RE: Review Comments
Tierra Linda Apartments
Albuquerque, NM
Plan Check No. PR-2021-005630
Project No. 24-2031-01

Below, please find our responses to your comments dated 12/11/24:

Reference: **Project Number 2021-005630**
 DFT Comment Response Letter

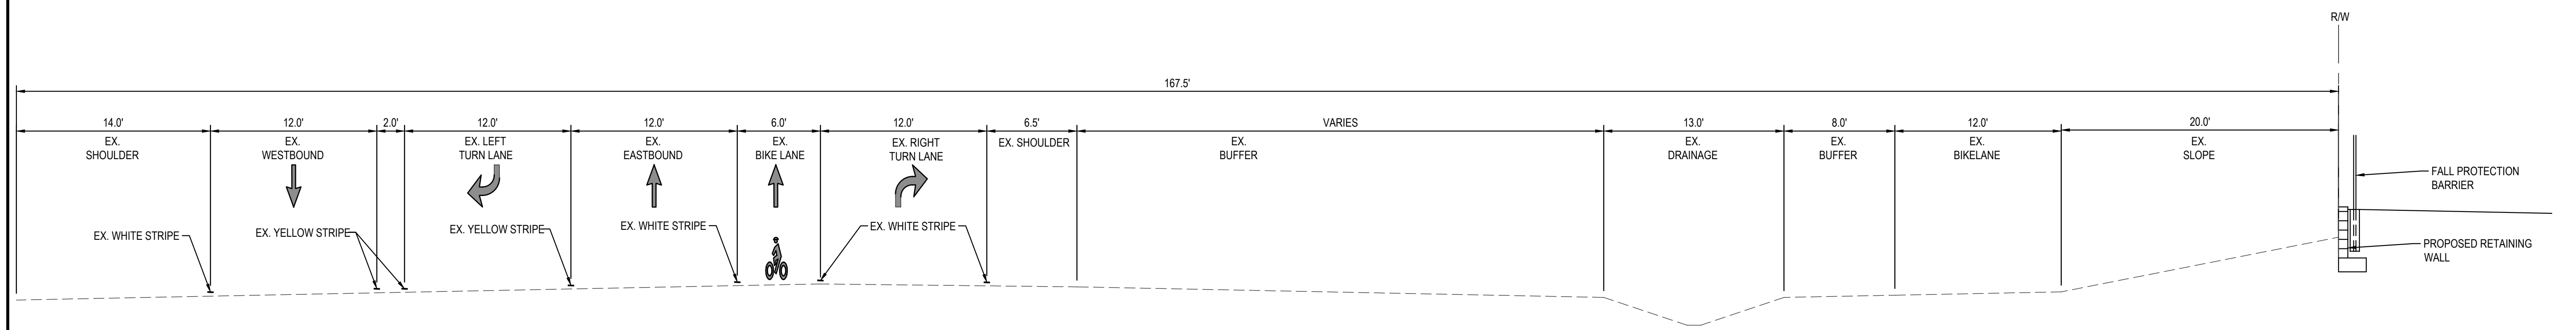
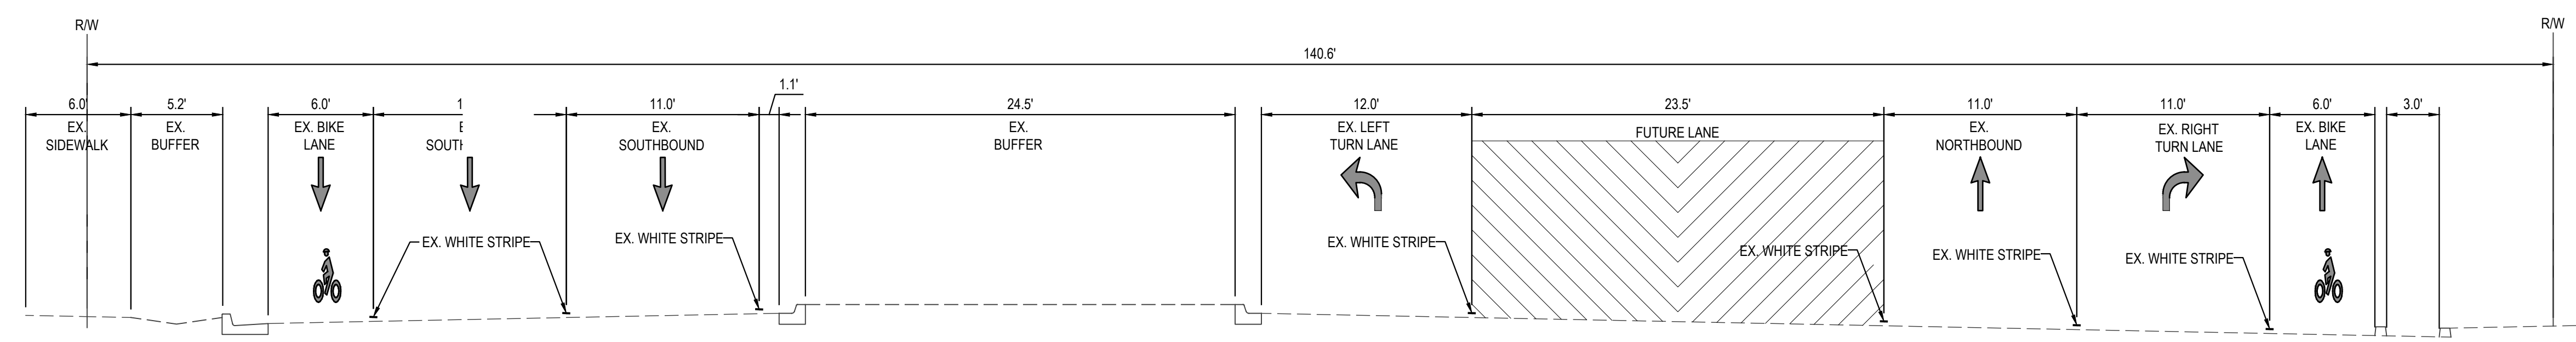
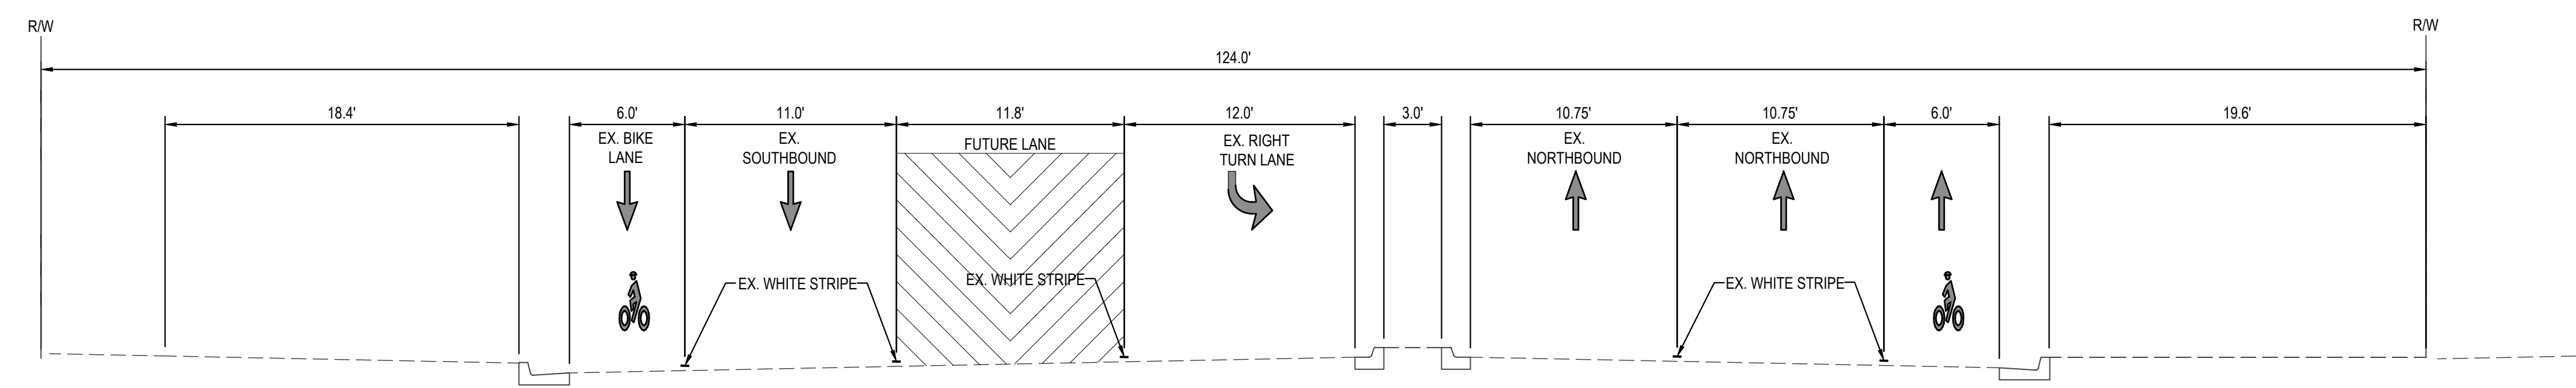
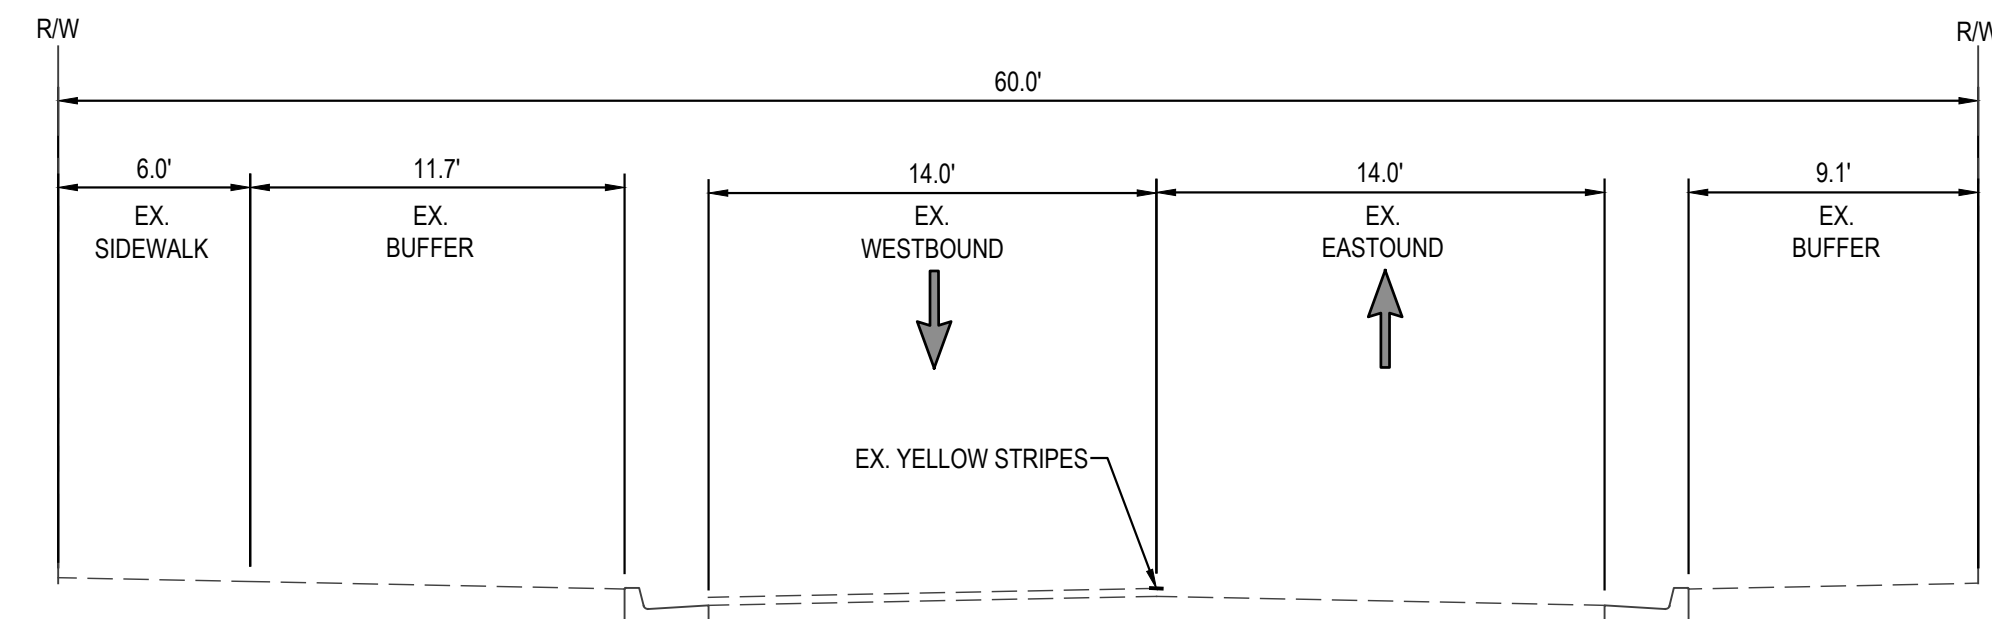
1. Please show width of existing sidewalks, multi-use trail and landscape buffers. Dennis Chavez is a Principal Arterial and 98th Street is a proposed Minor Arterial with both requiring 6' sidewalks with 5' to 6' landscape buffers. Ceja Vista is a local road and requires 5' sidewalk with 4' to 6' landscape buffer.

Comment #1: Please show width of existing sidewalks, multi-use trail and landscape buffers. Dennis Chavez is a Principal Arterial and 98th Street is a proposed Minor Arterial with both requiring 6' sidewalks with 5' to 6' landscape buffers. Ceja Vista is a local road and requires 5' sidewalk with 4' to 6' landscape buffer.

Comment: Verification of standards per Transportation. Please show width of existing sidewalks, multi-use trail and landscape buffers. Dennis Chavez is a Principal Arterial and 98th Street is a proposed Minor Arterial with both requiring 6' sidewalks with 5' to 6' landscape buffers. Ceja Vista is a local road and requires 5' sidewalk with 4' to 6' landscape buffer.

- *Street sections are shown on Sheets titled Proposed Street Section sheets 1 thru 4 and meet the requirements indicated above.*
2. Transportation has an approved Conceptual TCL dated 11/21/2024. A letter showing the current state of infrastructure completed will be required prior to clearing TIS requirement for the site plan approval. Prior to building permit a full TCL will be required.

Response: Street sections are shown on Sheets titled Proposed Street Section sheets 1 thru 4 and meet the requirements indicated above.
